FOURSQUARE AT STERLING RANCH EAST FILING NO. 1

UTILITY CONSTRUCTION PLANS

NOVEMBER 2022

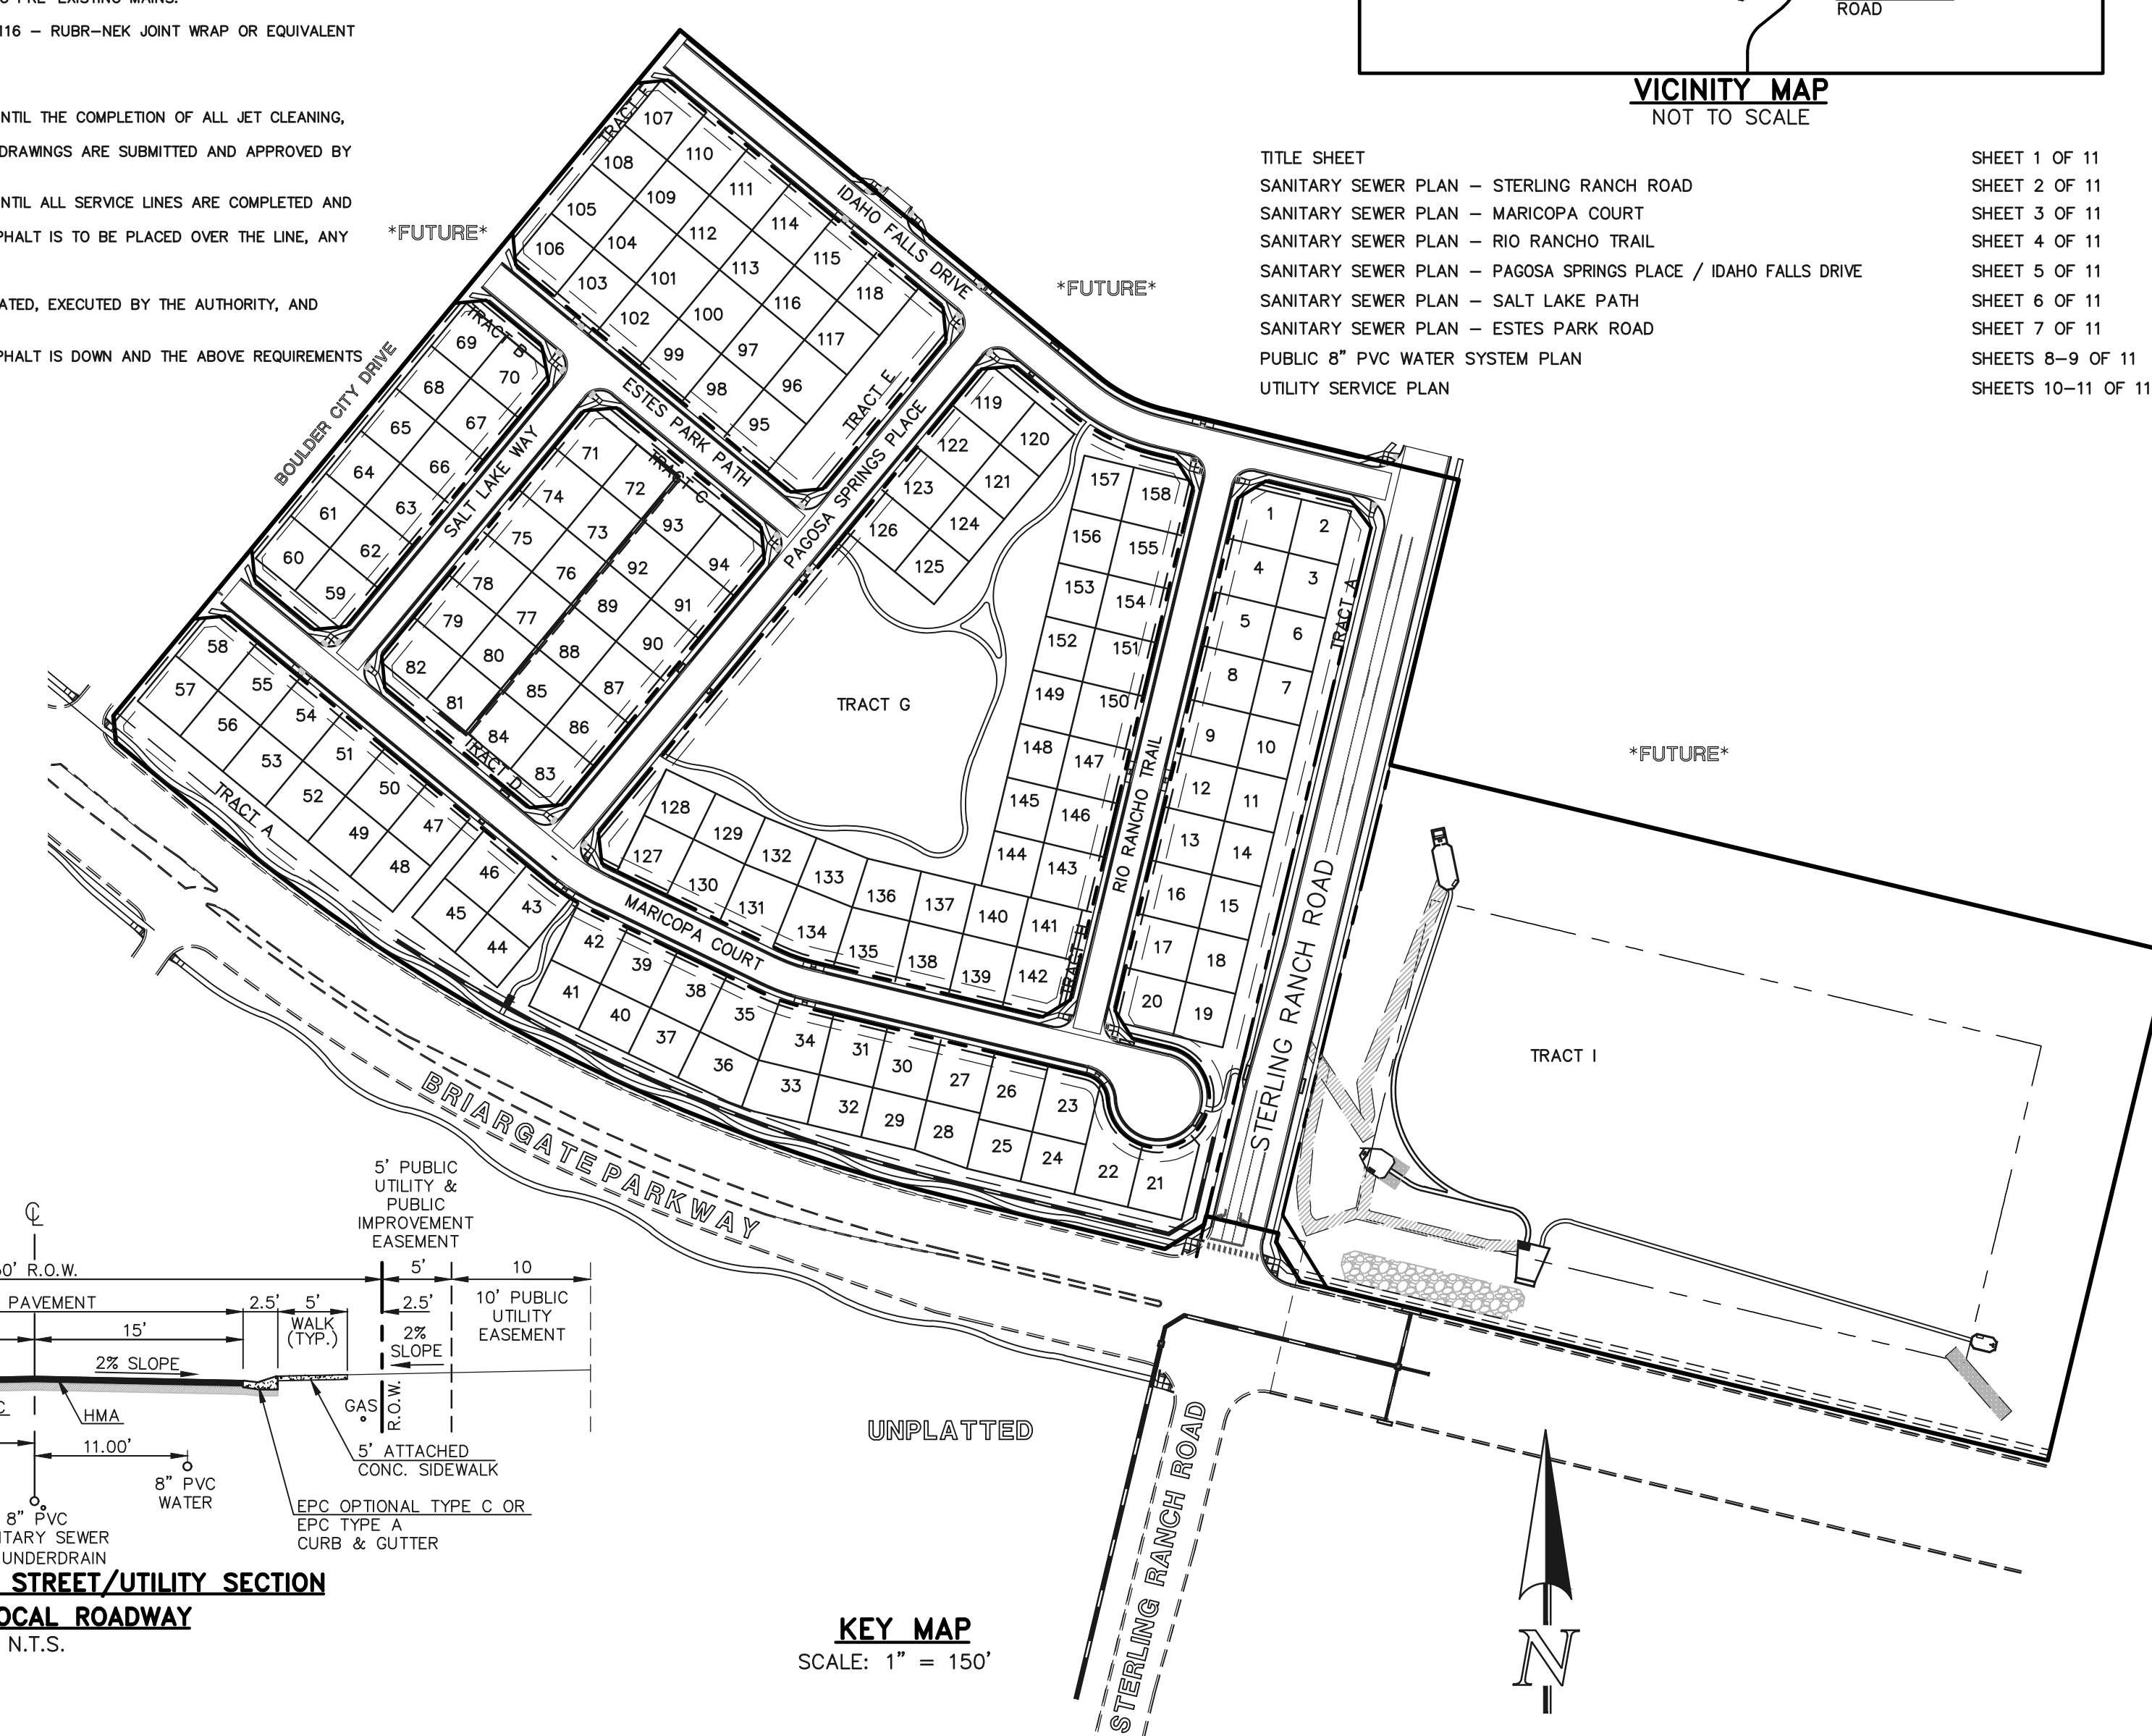
Unresolved, Add information for Basis of Bearings & Benchmarks

Add County signature block
